Letter No. B3/30781/05

Sub: CMDA - Area Plans Unit - Planning ^{clearance} Permission - ^{the proposed Addl.} for construction of
of G.P.L + 2 floors building for police station at SNO 1124/2
G.N.T Road of Madhavaram. - Appd. regd.
Ref: 1) PPA received in ~~SBC No~~ RC No 164/43709/HST-3(1)/2005
at 27.12.05
2) RC No 164/43709/HB
3) Adm Comd Lt dt 18.03.2006 along with Revised Plan
furnished

The Planning ^{clearance} Permission Application and Revised Plan received in the reference.
cited for the ^{proposed Addl.} construction/development of G.P.L + 2 floors building for
Police station at SNO 1124/2, G.N.T Road of Madhavaram, Chennai

RAIN WATER HARVESTING THROUGH DEFUNCT BORE WELL

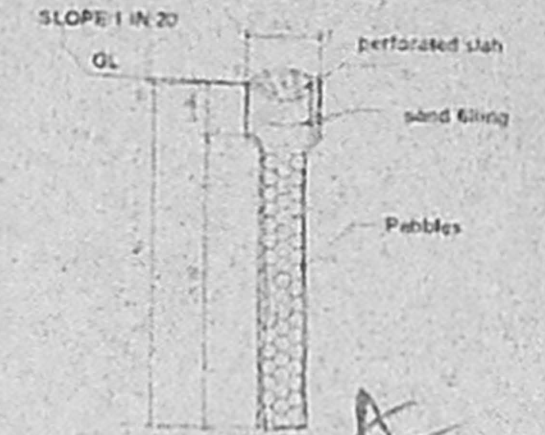
2) Non provision of Rain Water Harvest structures as shown in the approved plans to the satisfaction of the Authority will also be considered as a deviation to the approved plans and violation of Development Control Rules and enforcement action will be taken against such development.

O.S.R.	
O.S.R. AREA REQUIRED (10% OF TOTAL SITE AREA)	100.00 Sqm.
O.S.R. AREA PROVIDED	100.00 Sqm.

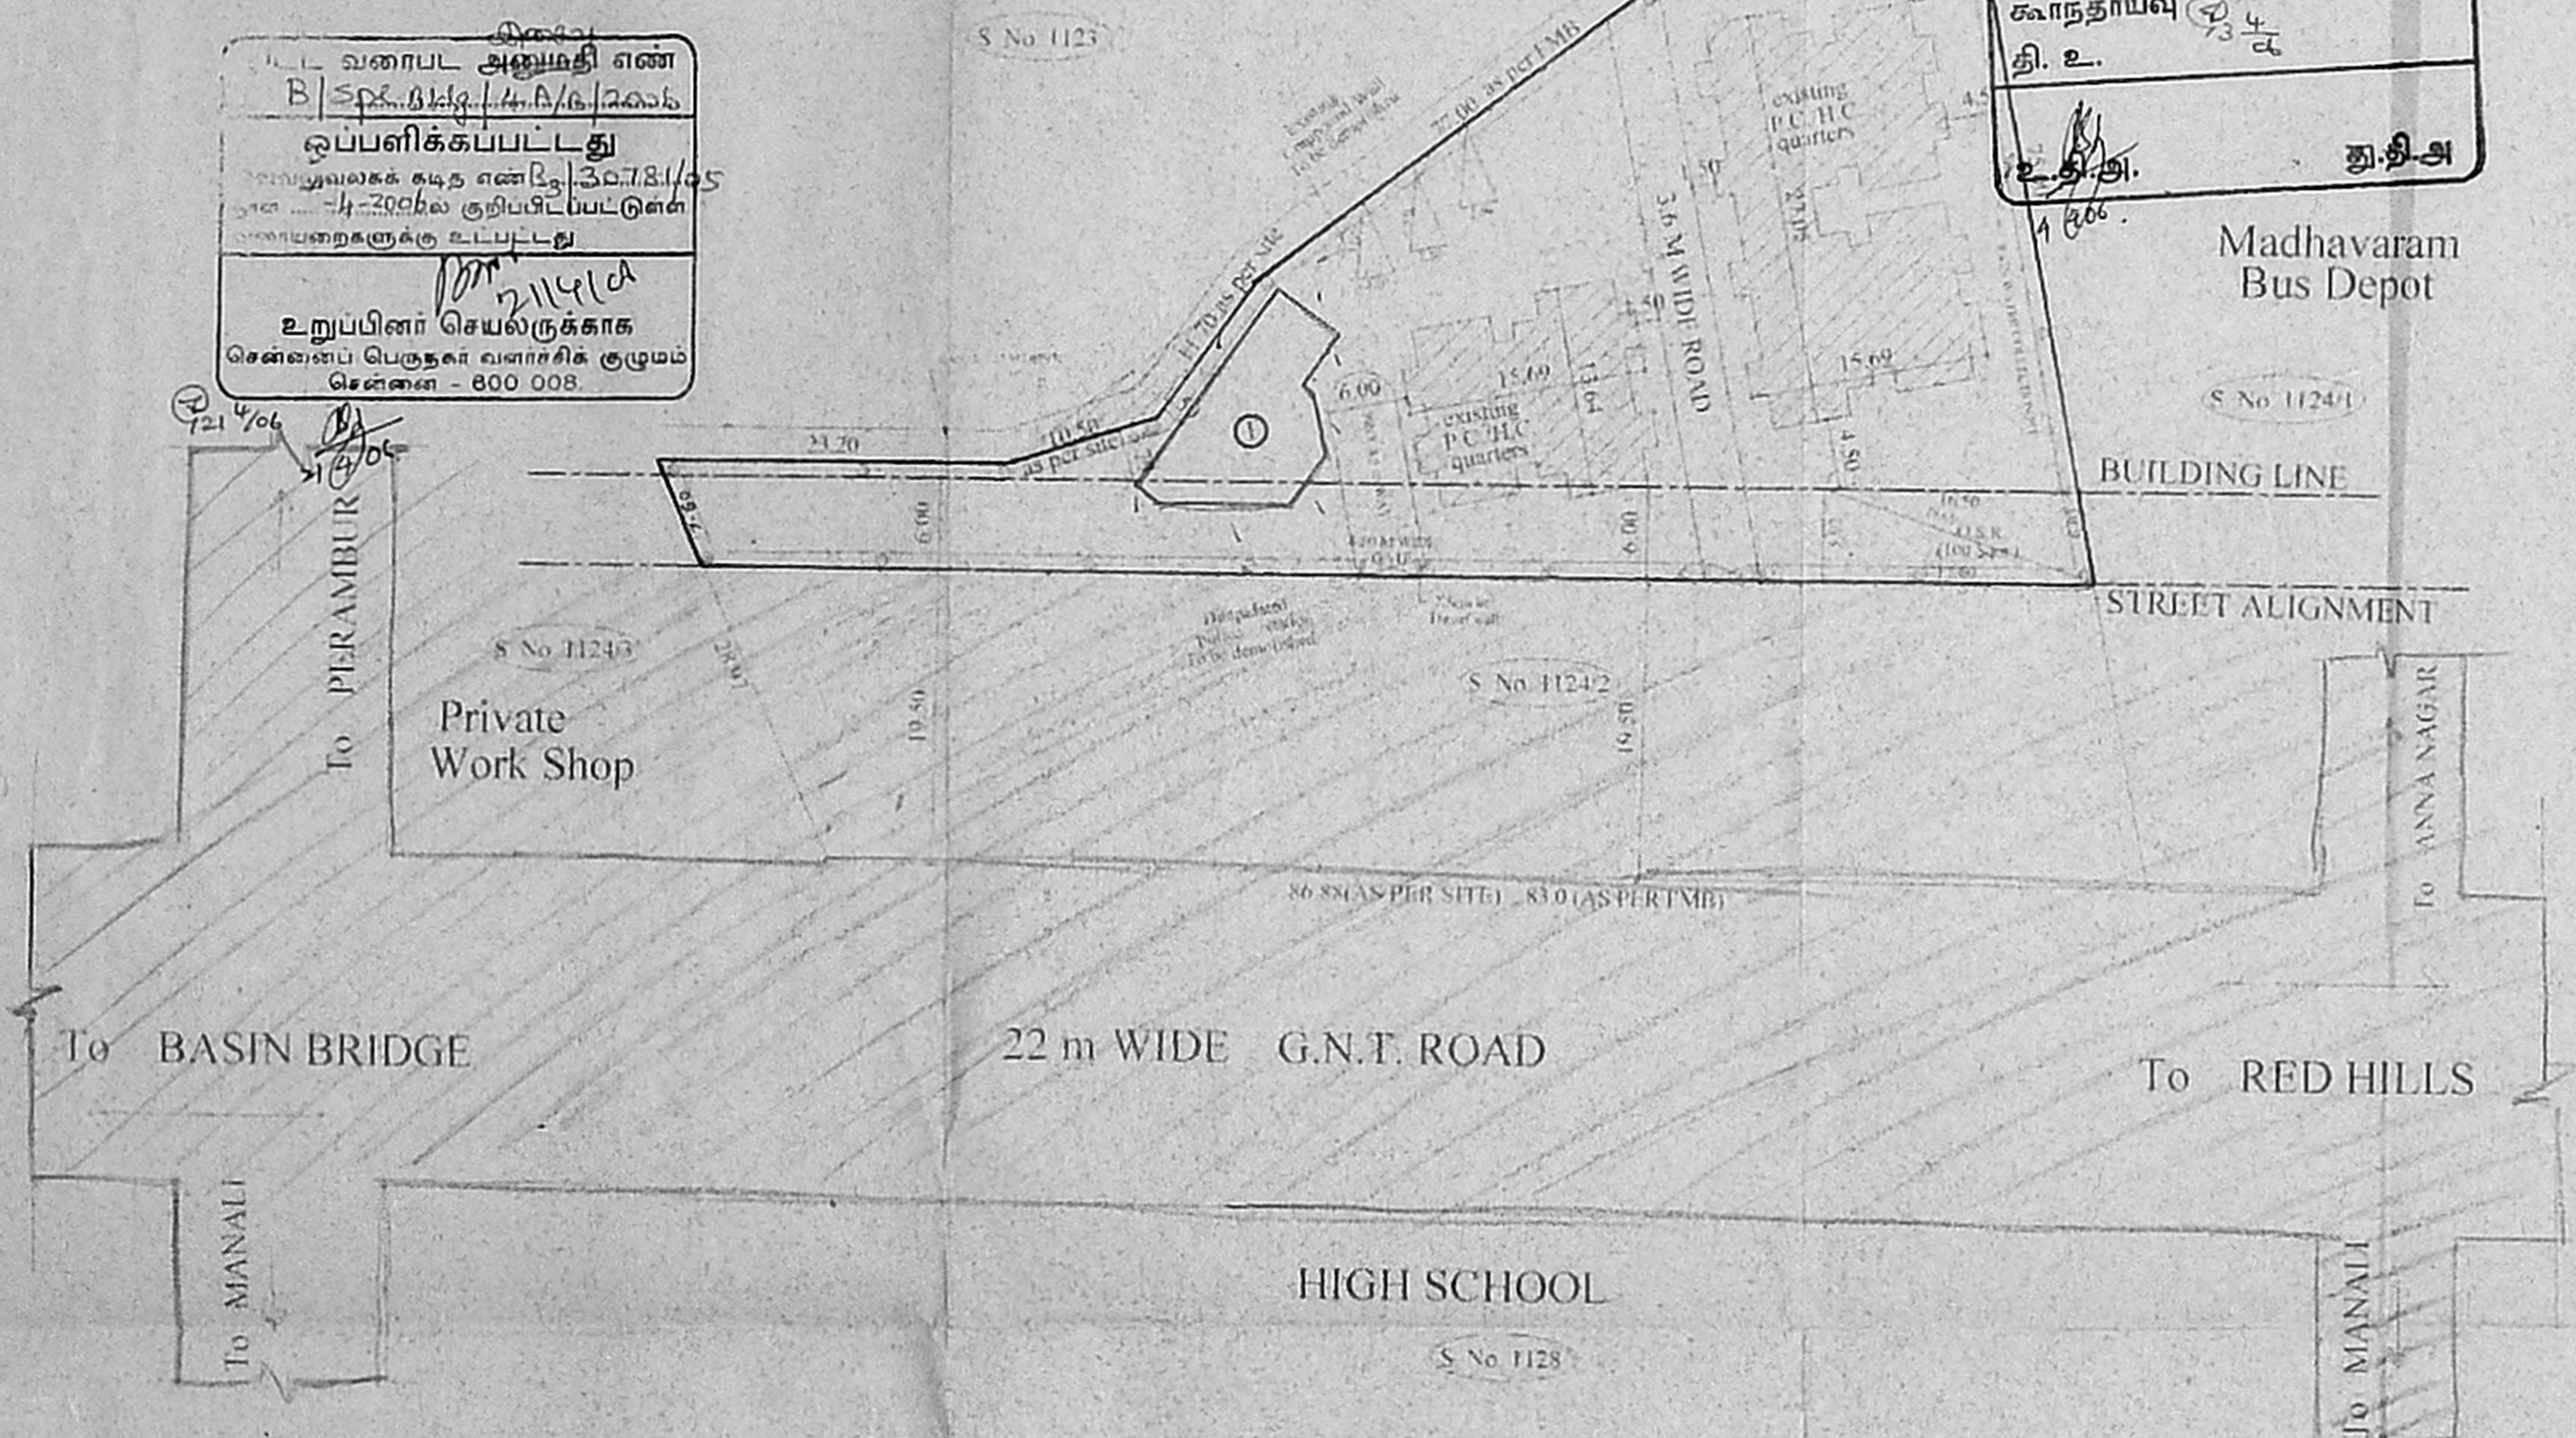
has been approved subject to the conditions ~~incorporated in the reference~~ that the space
shown as O.S.B in the plan shall be demarcated with
fencing & maintained as park by police dept. without putting up
any structure thereon.
